From: Rachel . <blparishclerk@outlook.com>
Sent: 20 September 2022 19:13
To: Planning
Subject: 3/2022/0637

With reference to planning application 3/2022/0637

SHEET:  
**PROPOSED ELEVATIONS**

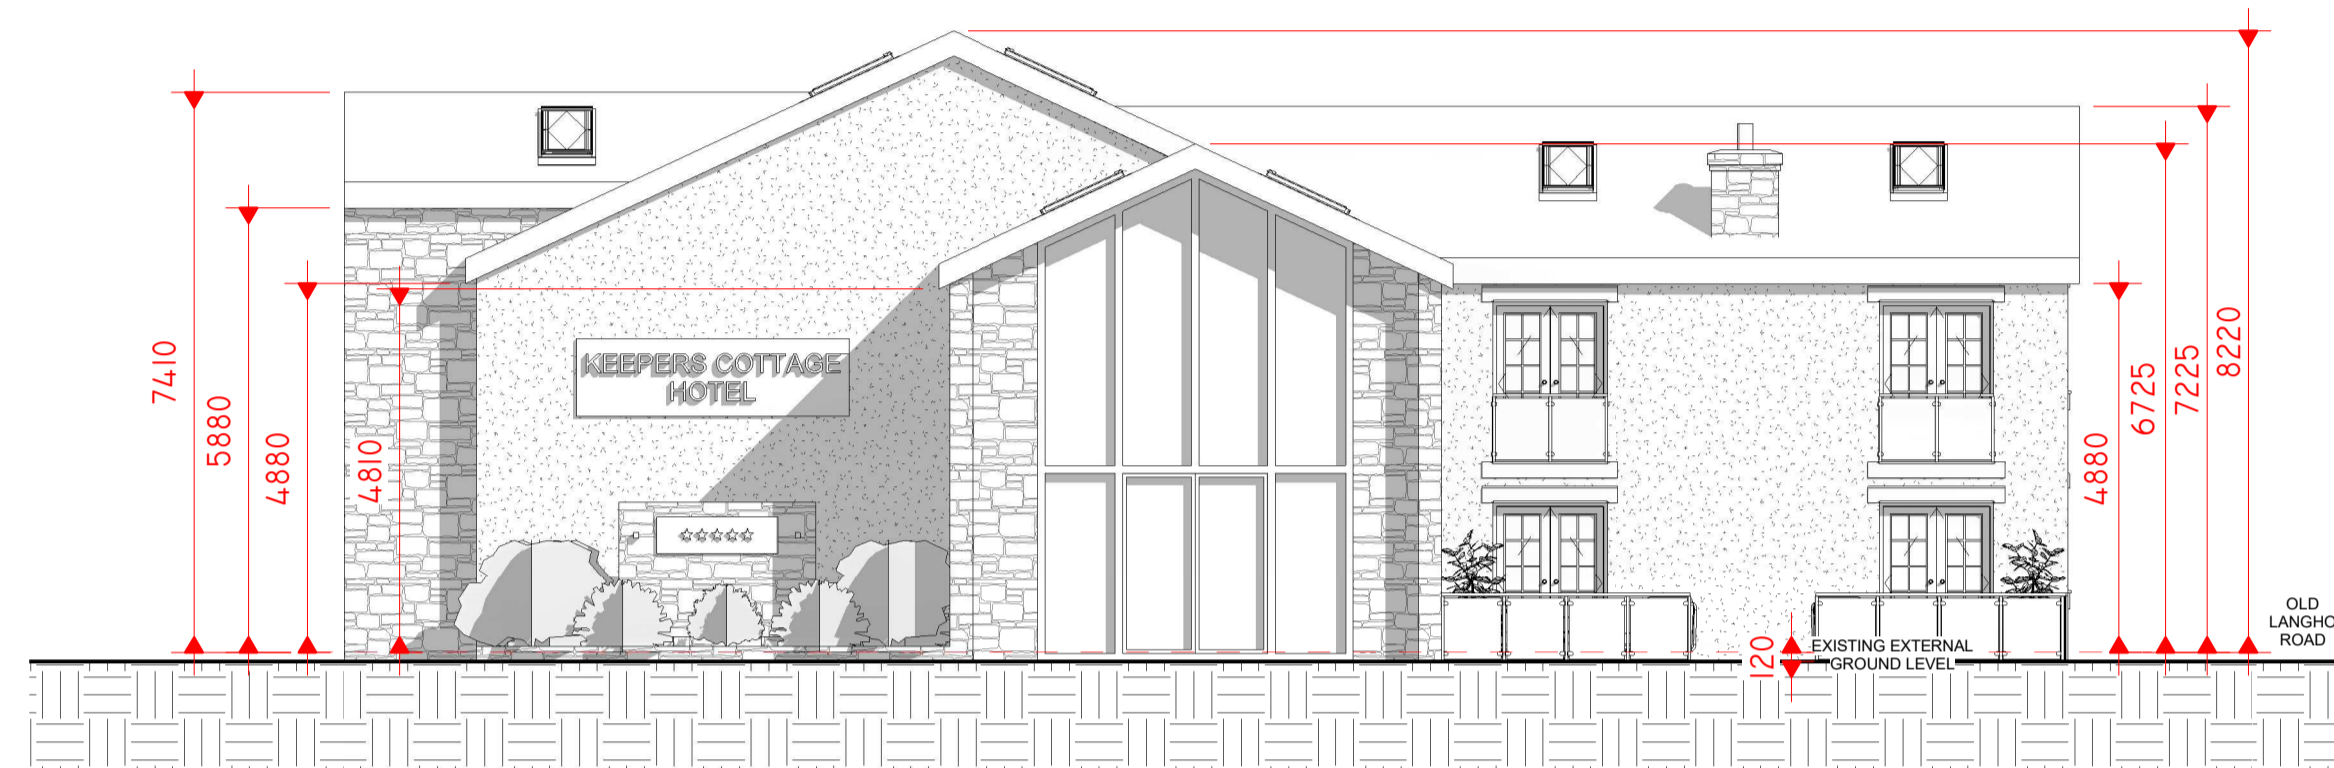
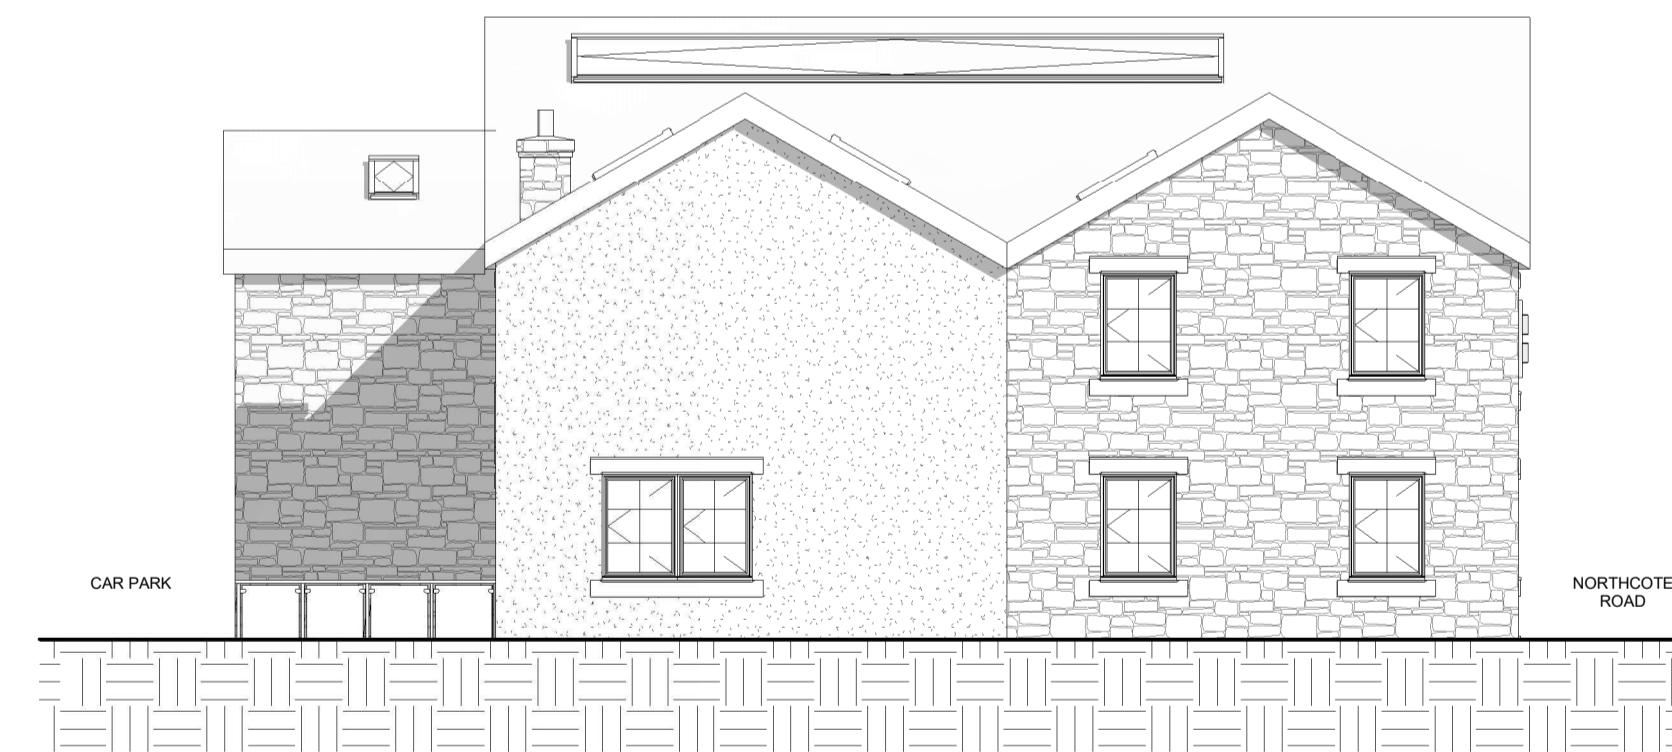
Looking at the artist impression of the building, the parish council felt that it does not fit in with nearby housing. The large raised roof sections in particular are not in keeping and the property footprint is huge compared to the original.
